18 October 2023

In response to the Site Plan submitted for the Fowler Creek Guest Ranch, I completed a high-level evaluation of the existing road conditions requested by residents of the Granite Creek community.

PROPOSED EMERGENCY INGRESS & EGRESS PLAN MAP - FOWLER CREEK GUEST RANCH

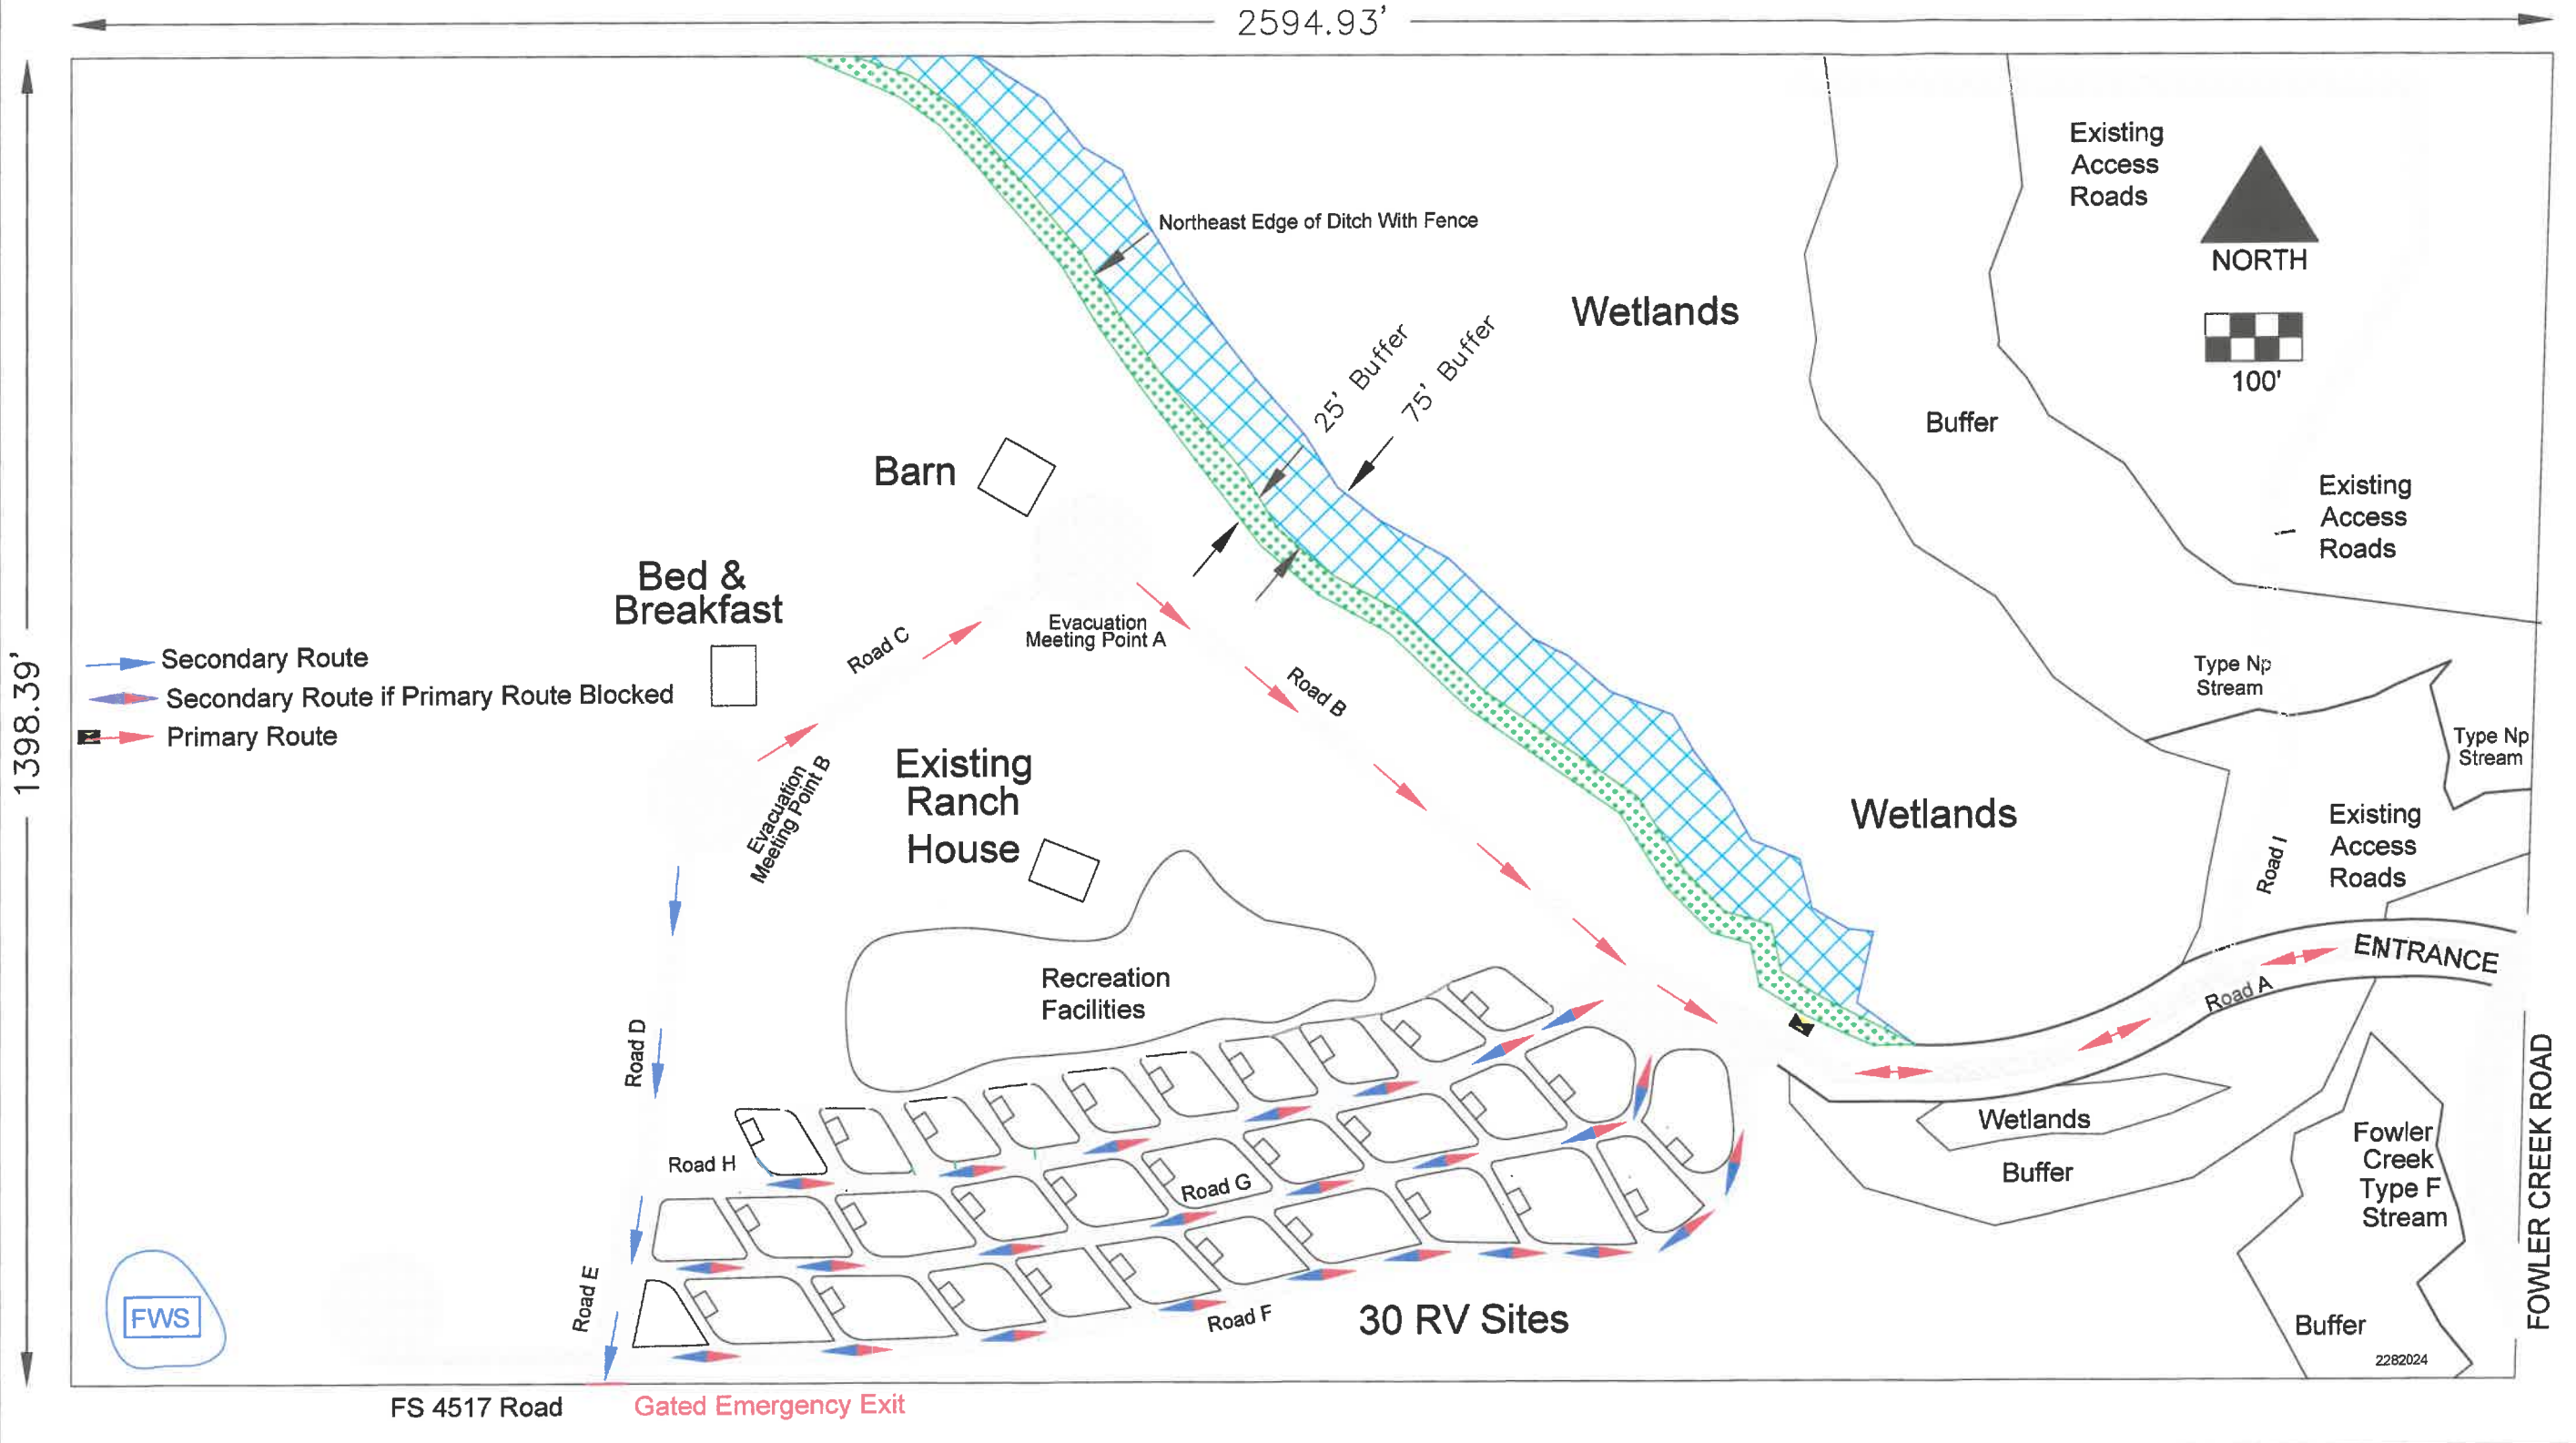
United States Forest Service (USFS) road 4517 is the single and readily available access into the Granite Creek community. On the Site Plan, the two points of access to the Guest Ranch are labeled "Exit" to USFS road 4517 and an "Entrance" from Fowler Creek Road. This access is currently unimproved and the "Exit" is the only means of egress from the Guest Ranch shown on the Site Plan.

My concern begins with the intersection of the "Exit" and USFS road 4517. In an emergency, such as a wildland wildfire, the traffic volumes proposed by the Guest Ranch combined with the residents and any vacation renters from approximately 120 lots in the Granite Creek community may exceed the capacity of this intersection and USFS road 4517. This existing USFS road may not have been designed and constructed to meet current standards for horizontal and vertical line of sight, stopping sight distance, turn radii for long wheel-base vehicles such as recreational vehicles, clear zone requirements, and roadway width for the traffic volumes and speed experienced in an evacuation scenario.

In my opinion the proposed intersection and USFS road 4517 may not be adequate to provide safe egress for the Granite Creek community. Further engineering analysis should be completed for the proposed Site Plan in the permit application to ensure the combined traffic volumes for the Guest Ranch and Granite Creek community can egress the area both safely and expeditiously. Additional upgrades or improvements to the proposed access at the Guest Ranch as well as USFS road 4517 may be required to meet current standards in conformance with the Kittitas County Code.
